**Re: Sandia Laboratory Federal Credit Union at 5700 St Joseph's Dr. NW  
Erosion and Sediment Control Plan  
Engineer's Stamp Date 1/4/24 (G11E067B)**

Based upon the information provided in your submittal received 1/11/2024, the above-referenced ESC Plan cannot be approved for Grading Permit or Building Permit until the following comments are addressed.

1. WOVEN WIRE FENCE TO BE FASTENED SECURELY TO FENCE POSTS WITH WIRE TIES.
2. GEOTEXTILE TO BE FASTENED SECURELY TO WOVEN WIRE FENCE WITH TIES SPACED EVERY 24\"/>

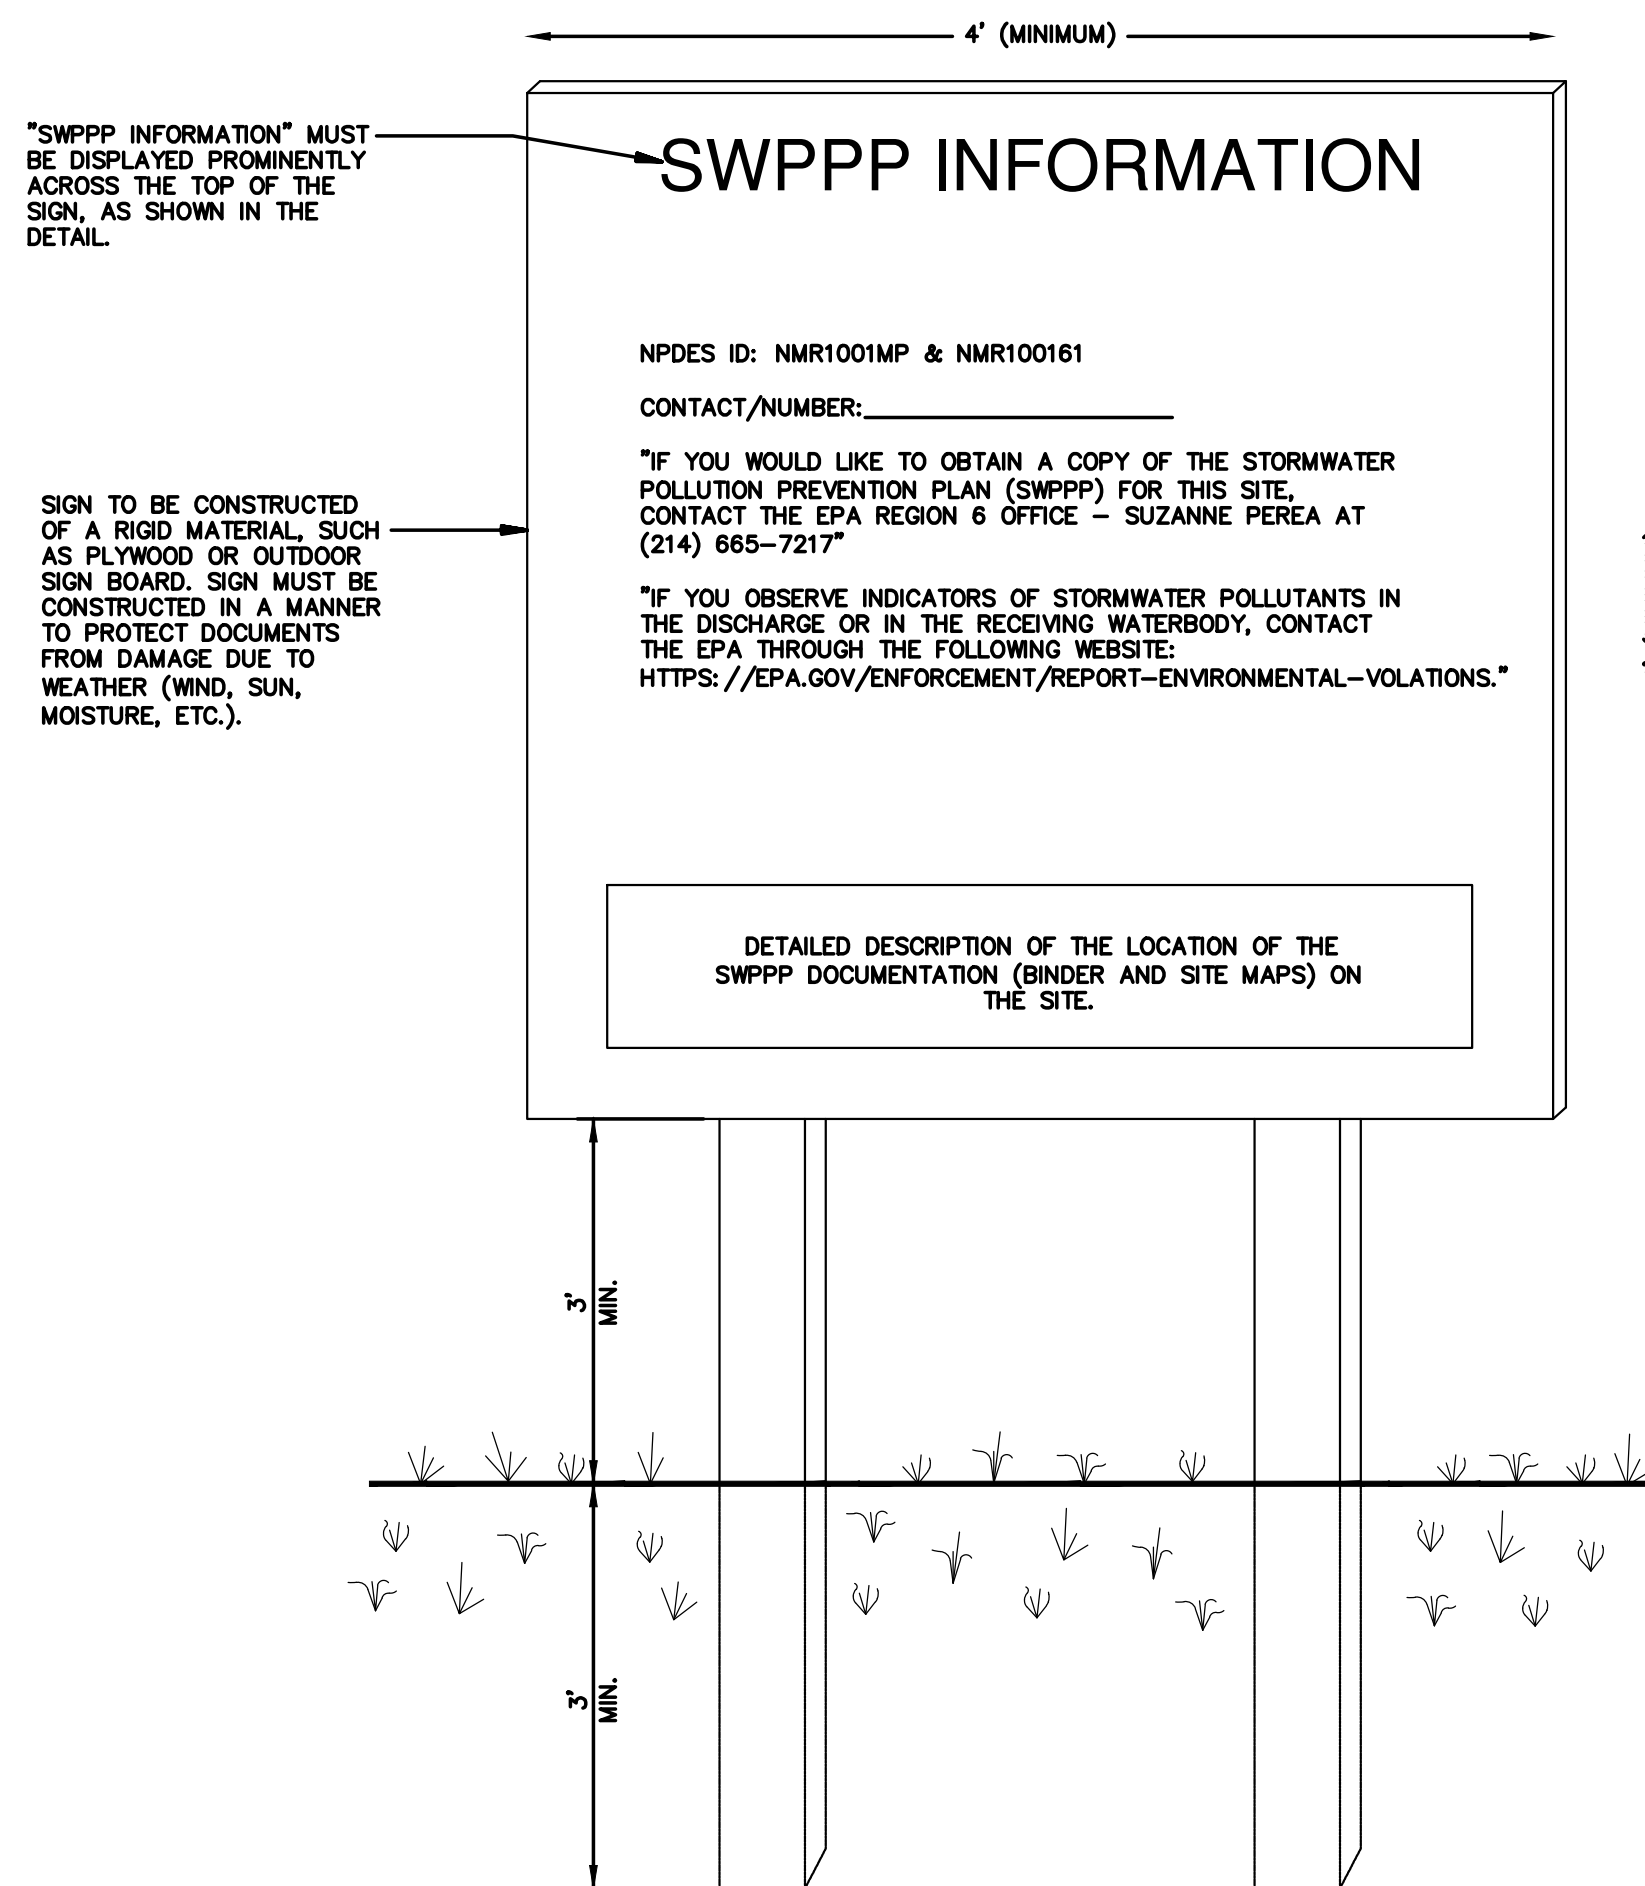
3. Provide calculations for the Sediment Trap design showing compliance with CGP Part 2.2.12.c which requires storage for either:
  - a. The calculated volume of runoff from a 2-year, 24-hour storm; or
